Planning Application Ref: BE/63/17/OUT (3)

Location: The Cottage, Shripney Road, Bognor Regis

Description of works: Erection of 21 new houses and flats with access and parking and landscaping.

Consultant Arboriculturist

Fig 2. Proposed Indicative Site Layout Plan

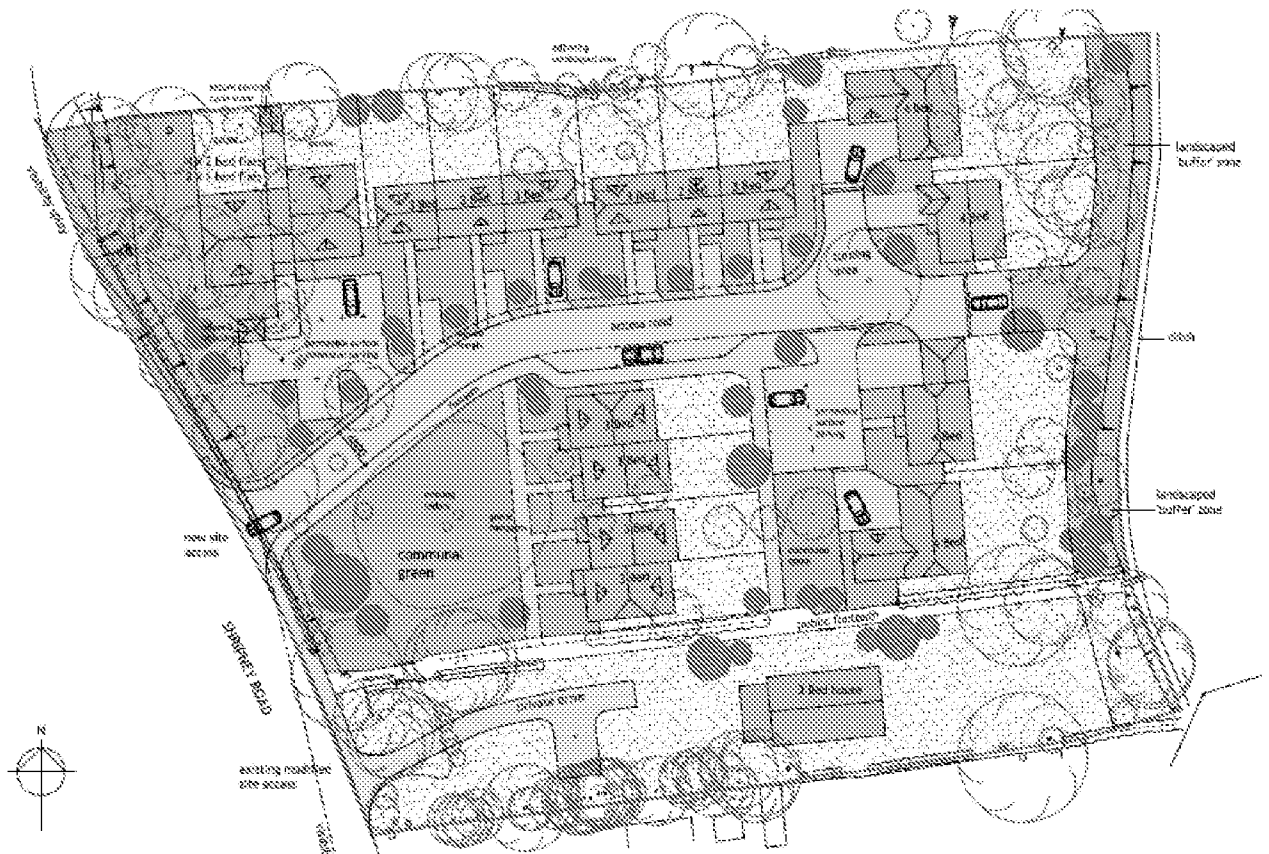
- My only remaining concern on this scheme is the footpath link across the front of the site linking both access points – is this really needed as it cuts right through the RPA of TPO'd tree **Sycamore T35**? Can they not move the two parking bays to one side (east) and extend the current footpath to the east side of **T36/37 Cedars** to link to the isolated Plot to the south?

- If this final adjustment can be made then I would be able to lend the scheme my full support – as it stands I would have to sustain an **OBJECTION** because of adverse impact on **Sycamore T35**.
